CITY OF ALBUQUERQUE

PLANNING DEPARTMENT – Development Review Services

RE: **Legacy Church – West Access Road**
7201 Central Avenue NW

File: **K10-D015**
PE Stamp Dated: 05-02-13

LEGACY CHURCH
TOPOGRAPHIC SURVEY

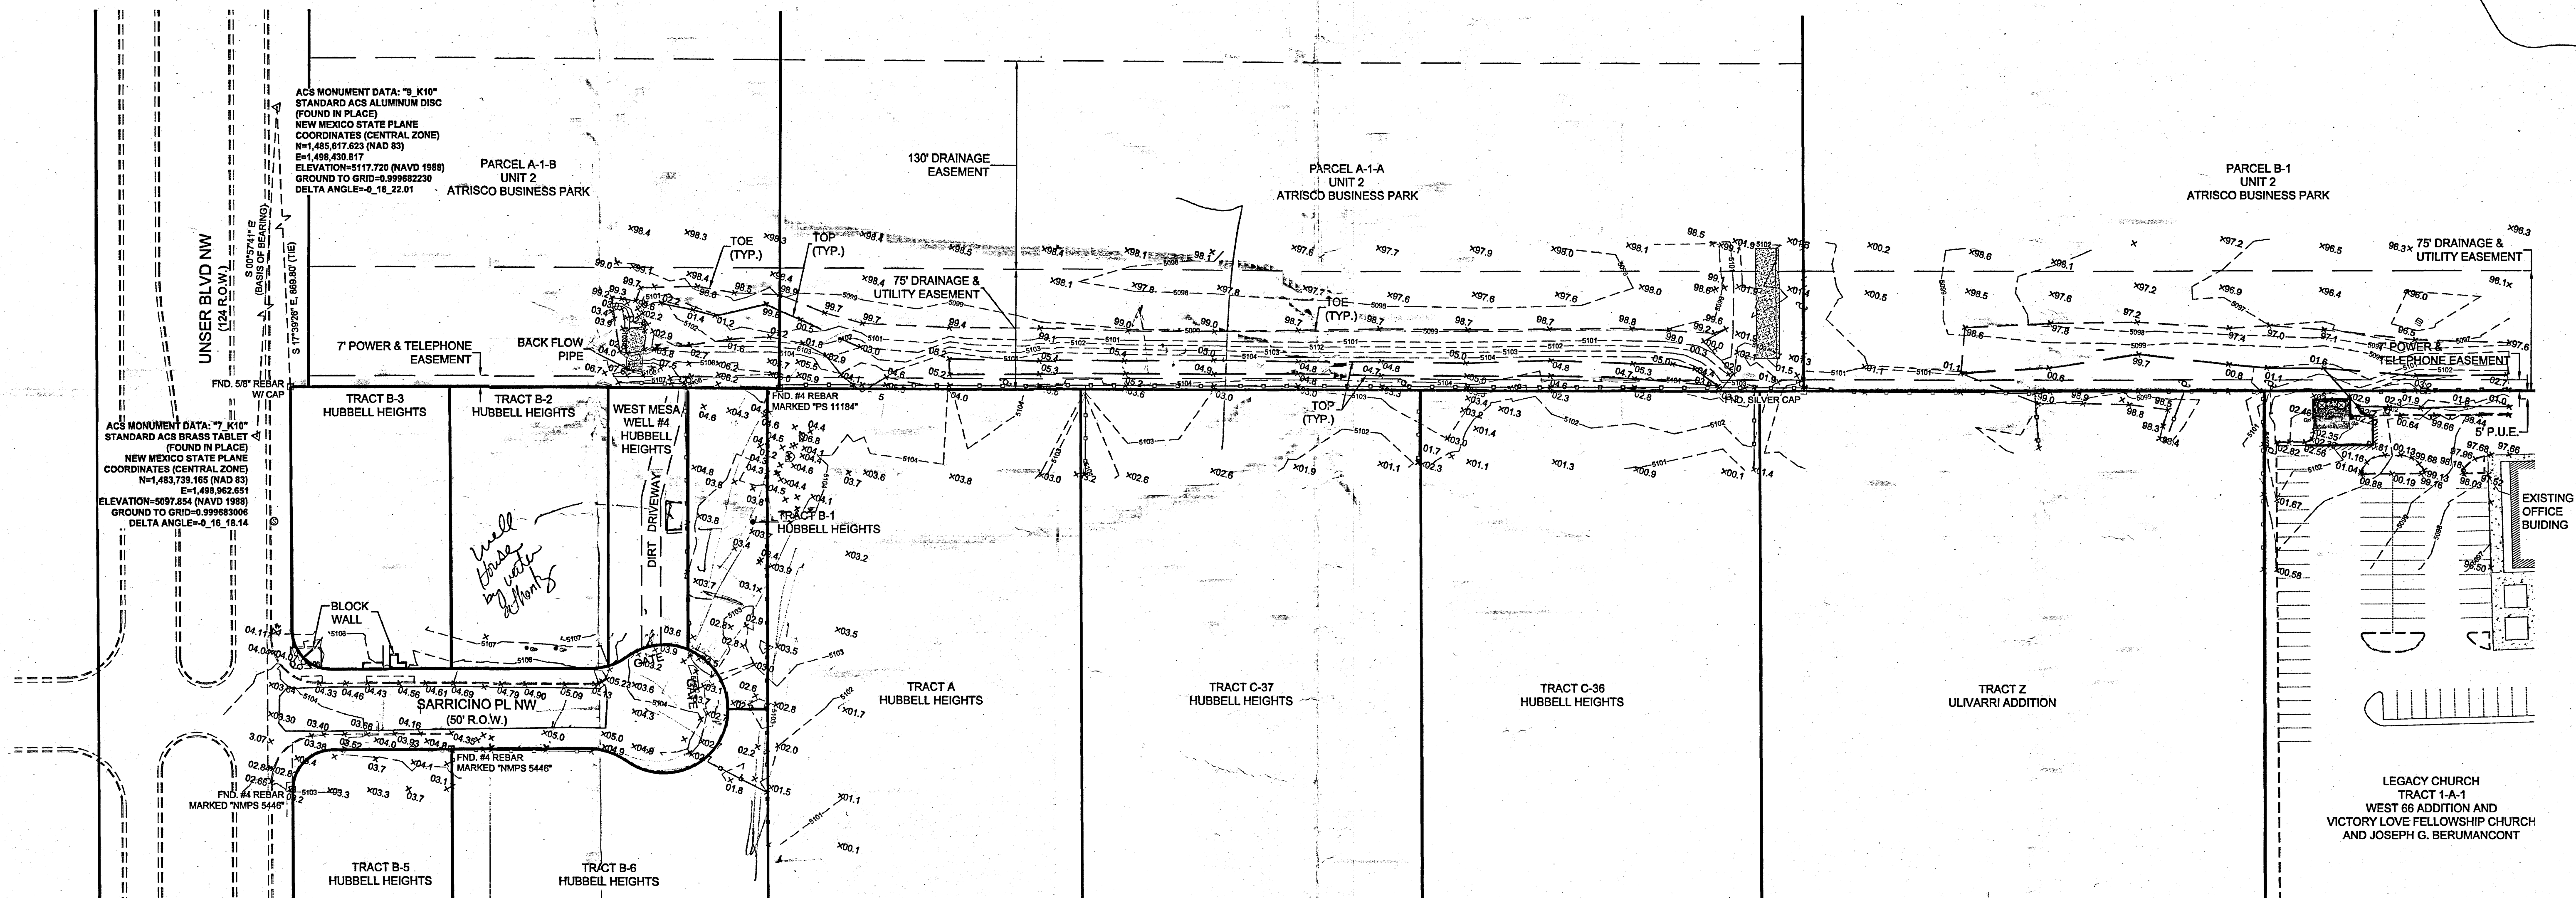
5. The expansion of the Sandia Distributing parking area on the north side of the pond (c2008), appears to have significantly reduced the pond volume, however that area was not surveyed in your April 2013 topo.

8. The grading and drainage plan for Sandia Distribution Center shows a maintenance access ramp on the south side of the pond, which is not on the survey, and may needed to be added, or relocated, in conjunction with the proposed roadway.
